RE: 2825 W. Mercer Way Preliminary Plat – Second Review SUB19-002/SEP19-005
Blueline Job No. 13-118

This letter is in response to the City's review of the 2825 W Mercer Way project. The plans have been revised per the comments in the letter, dated January 5, 2022. Below is a list of each comment with our responses in bold.

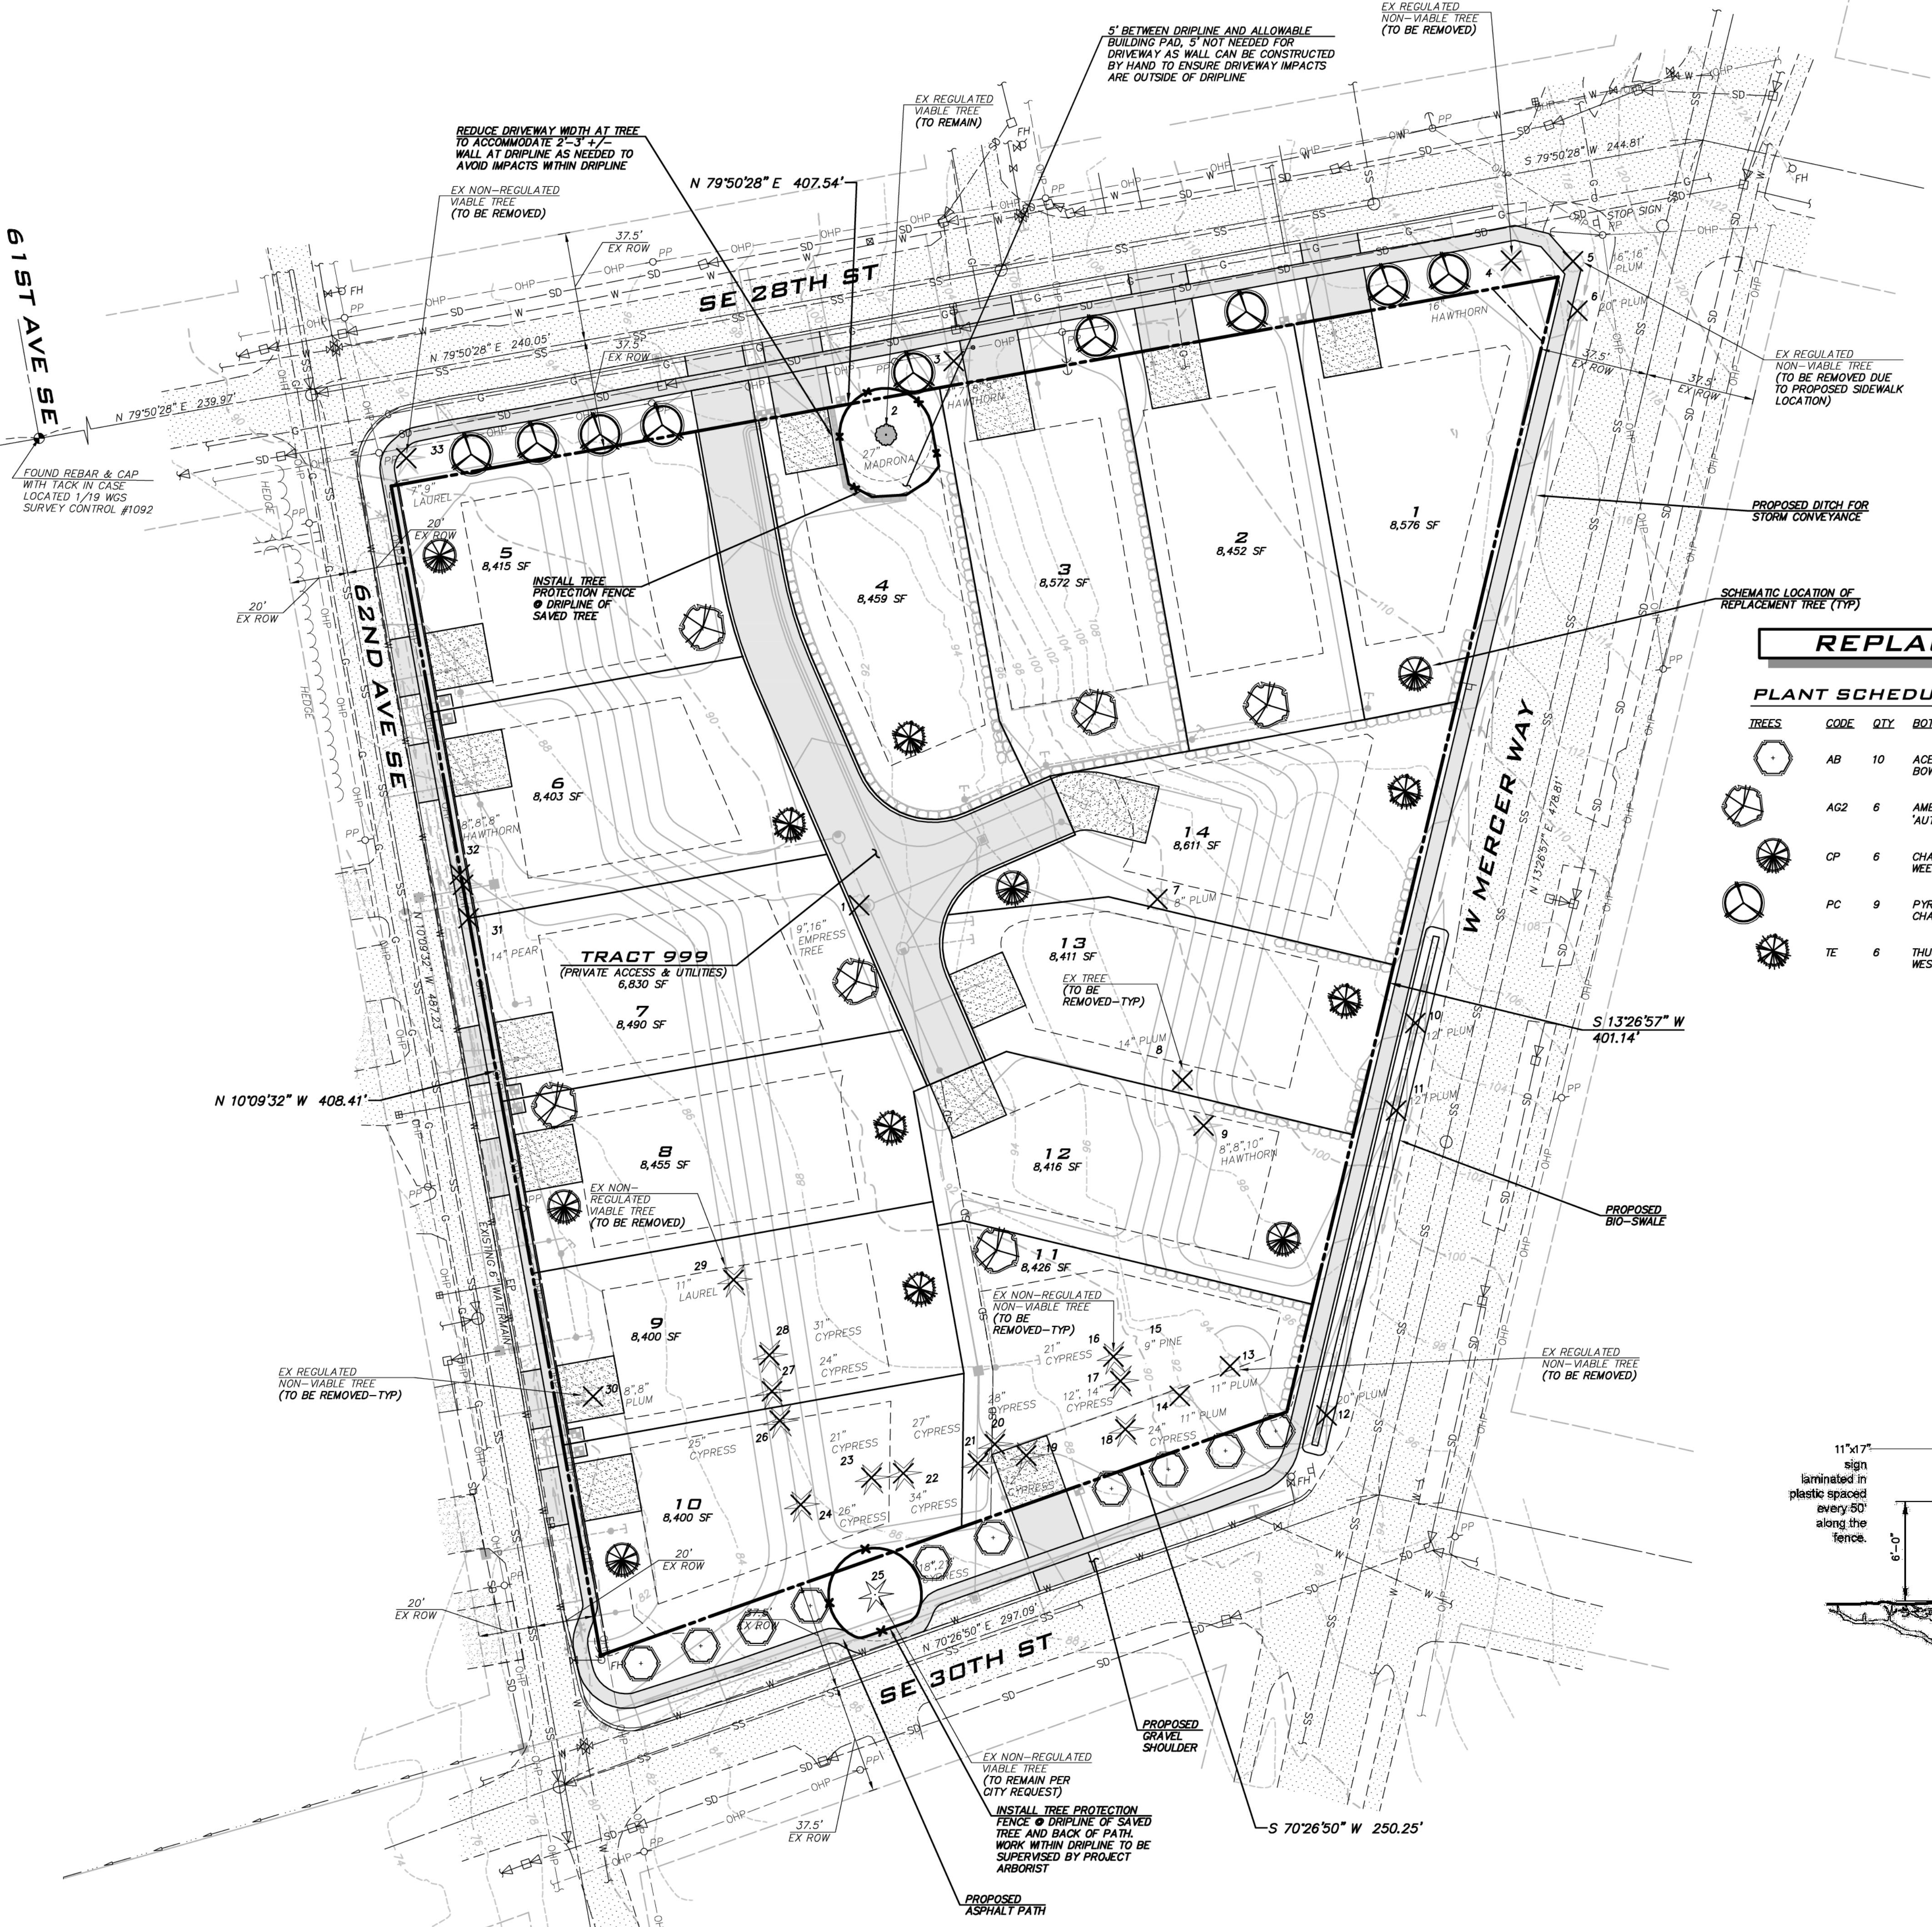
1. A new wall not shown in Sub 1 looks to be within the tree protection zone. The construction of the wall is shown encroaching into the tree protection zone. Place this wall with enough room to construct without encroaching into the tree protection zone. As suggested in a Planning comment a longer driveway would resolve this issue.

2. Show tree 2 protected at 16' and call this out. Building pad, driveway, grading and wall to be shown outside that limit with enough space to reasonably construct building. This means showing at least 5' of space between building pad and driveway in addition to the 16' of protection.

This wall was added to accommodate the lot 4 driveway while minimizing impacts to tree #2. The wall is located outside of the tree protection zone. The wall was shifted south 5' to the edge of the allowable building pad to provide additional protection. The wall can be constructed by hand along the driveway to ensure impacts are outside of the dripline.

Refer to tree protection fencing shown on sheet TR-01. The wall was shifted south 5' to the edge of the allowable building pad to provide additional protection. The wall can be constructed by hand along the driveway to ensure impacts are outside of the dripline.
